From: Guy Hickman [REDACTED]
Sent: 10 January 2020 11:57
To: Amber Willard <Amber.Willard@arun.gov.uk>; Planning <Planning@arun.gov.uk>
Cc: [REDACTED]
Subject: Comments regarding AW/338/19/HH : 9 Meadow Way PO21 4HG : Rear extension with internal adaptations etc.....

AW/338/19/HH : Rear extension with internal adaptations. New pitch roof to front porch.
Replacement windows, new
cladding and render to all external walls. Proposed rear Balcony: 9 Meadow Way Aldwick
PO21 4HG

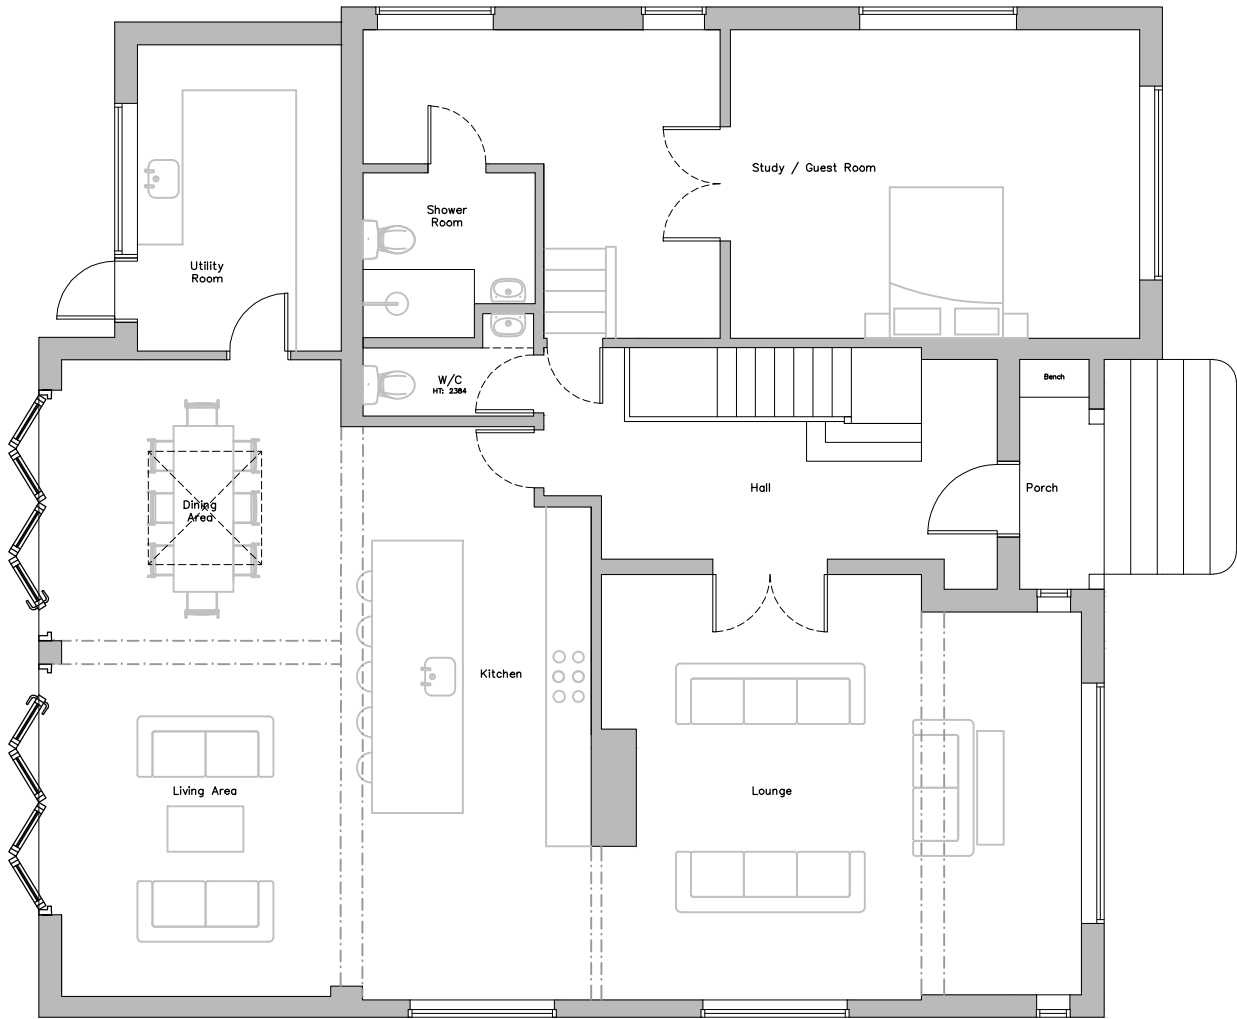
The proposed site plan and ground floor plans do not indicate the new raised ground floor balcony, this will be 1.0m above ground level, adjacent to our 1.8m close boarded, south boundary fence.

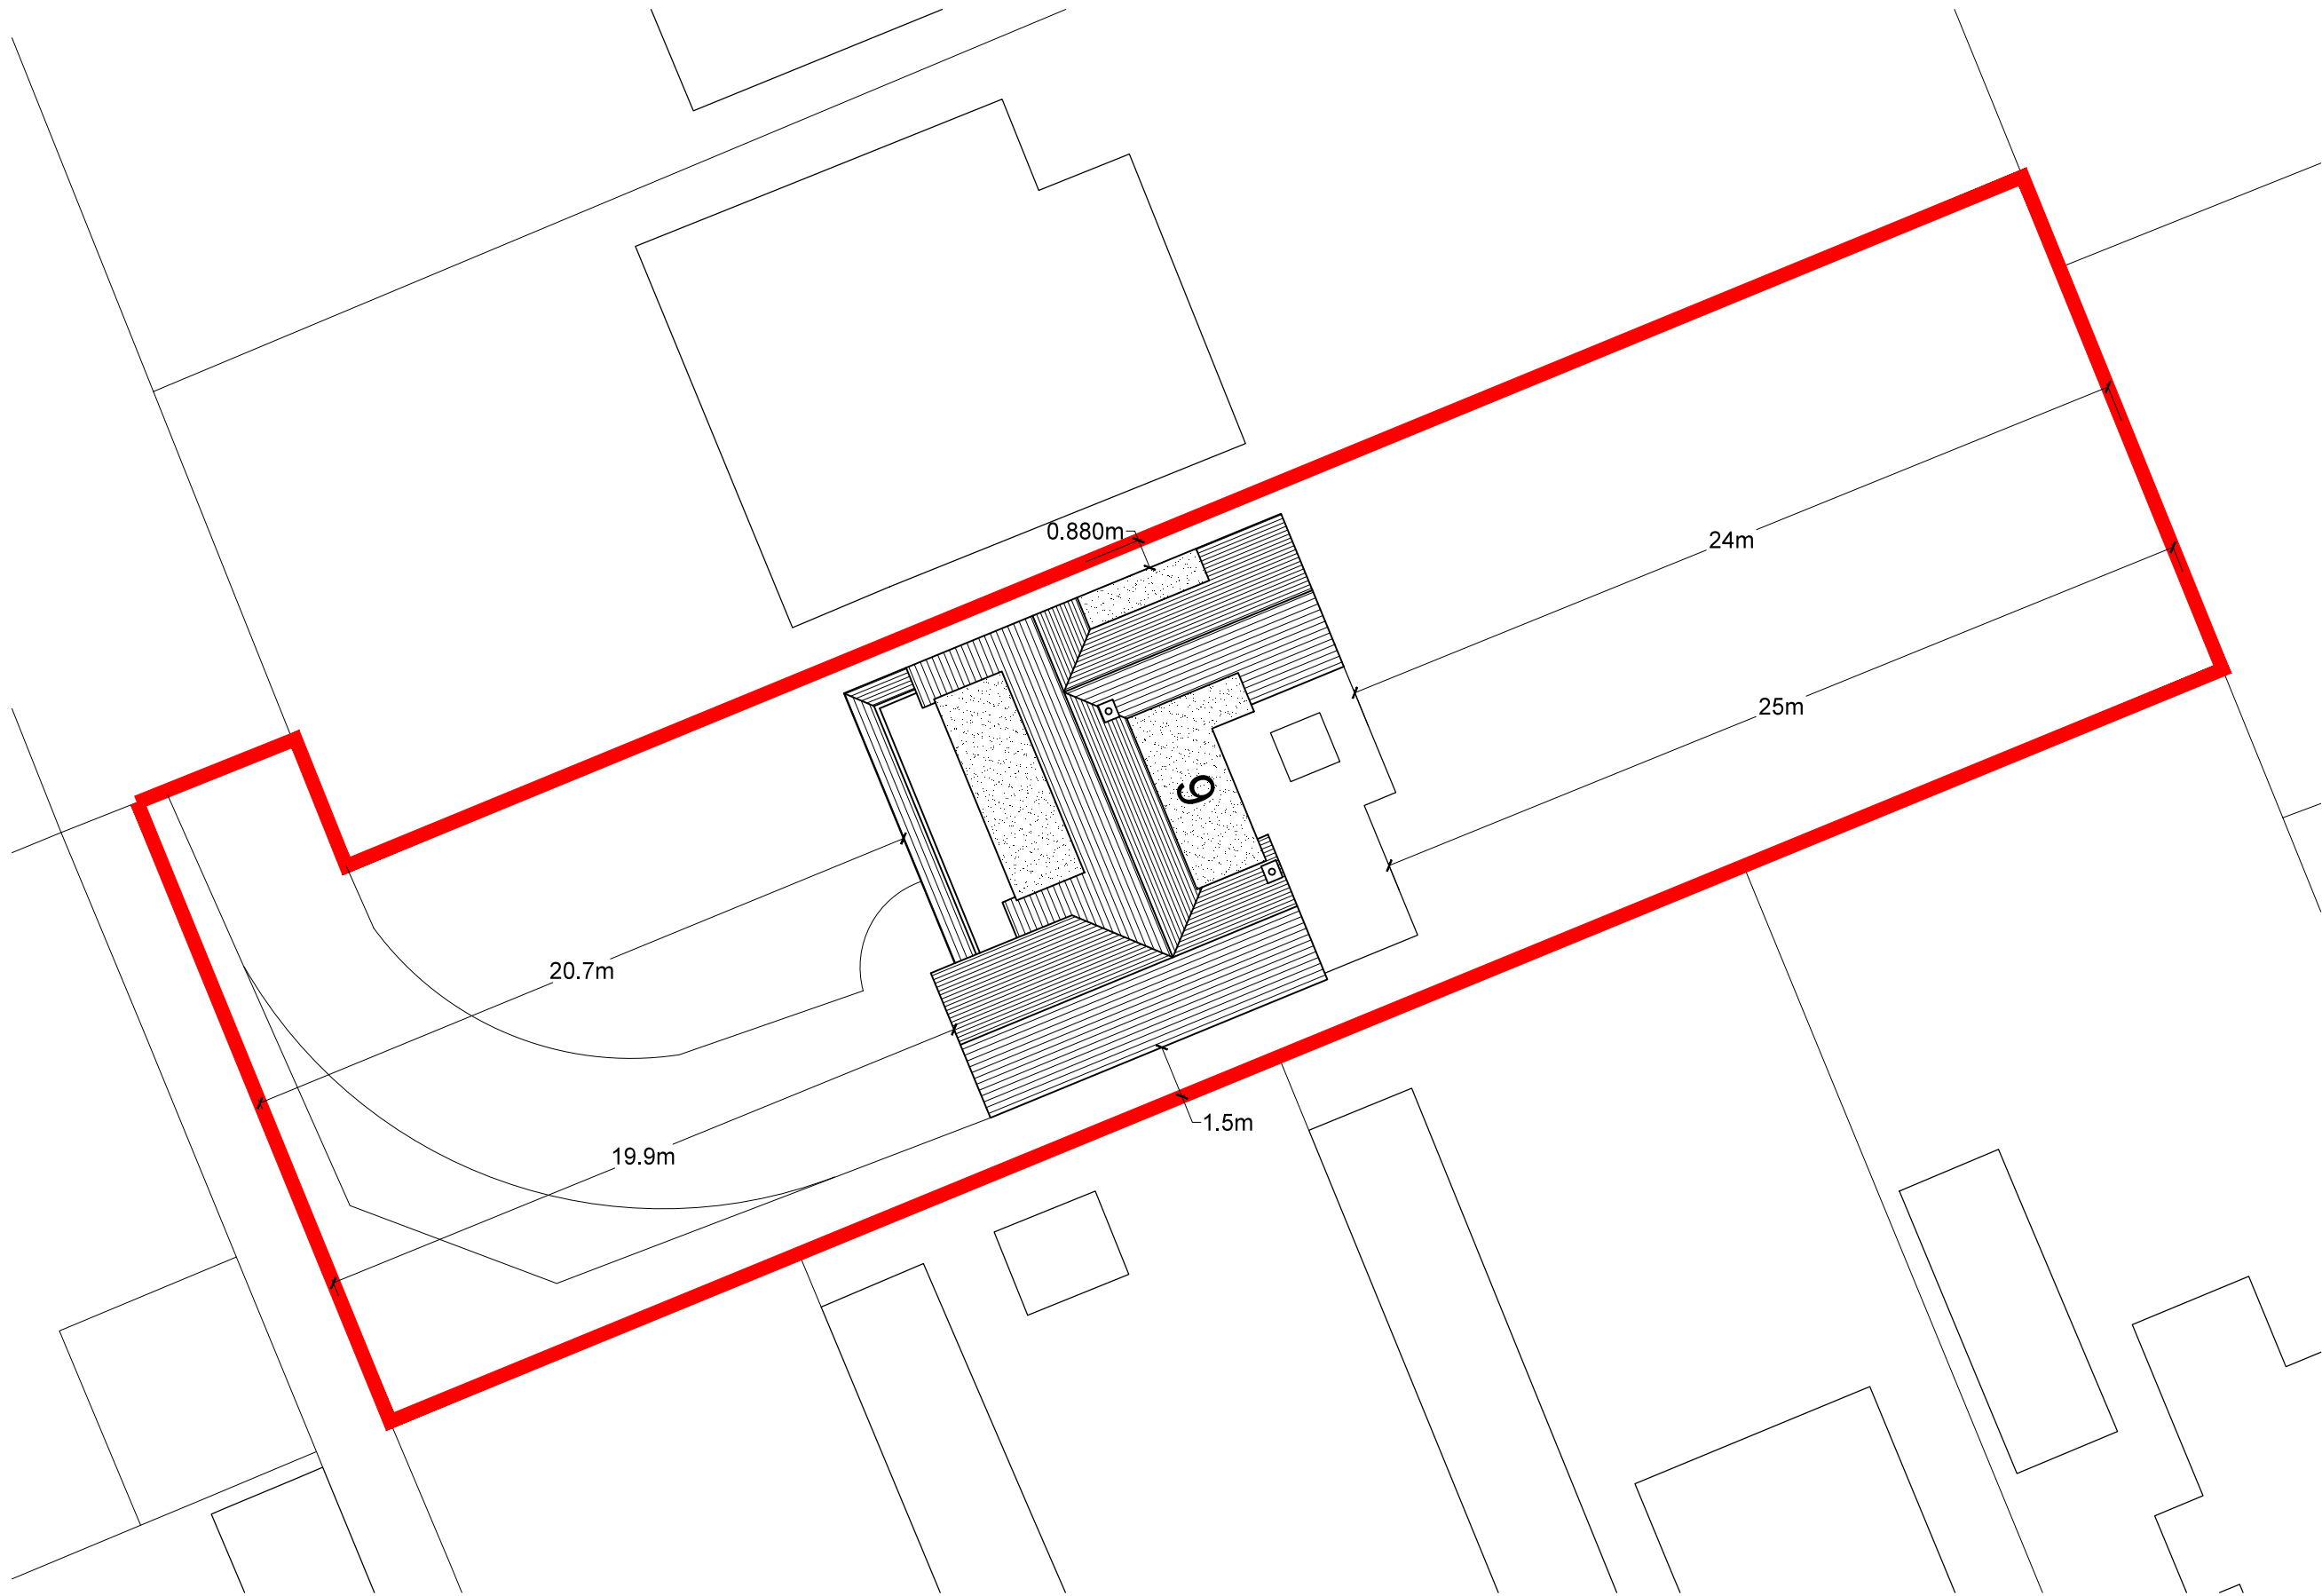
Without screening on the north side of this raised ground floor balcony, this will compromise our garden terrace privacy. The attached photographs indicate the existing houses and across our rear terrace
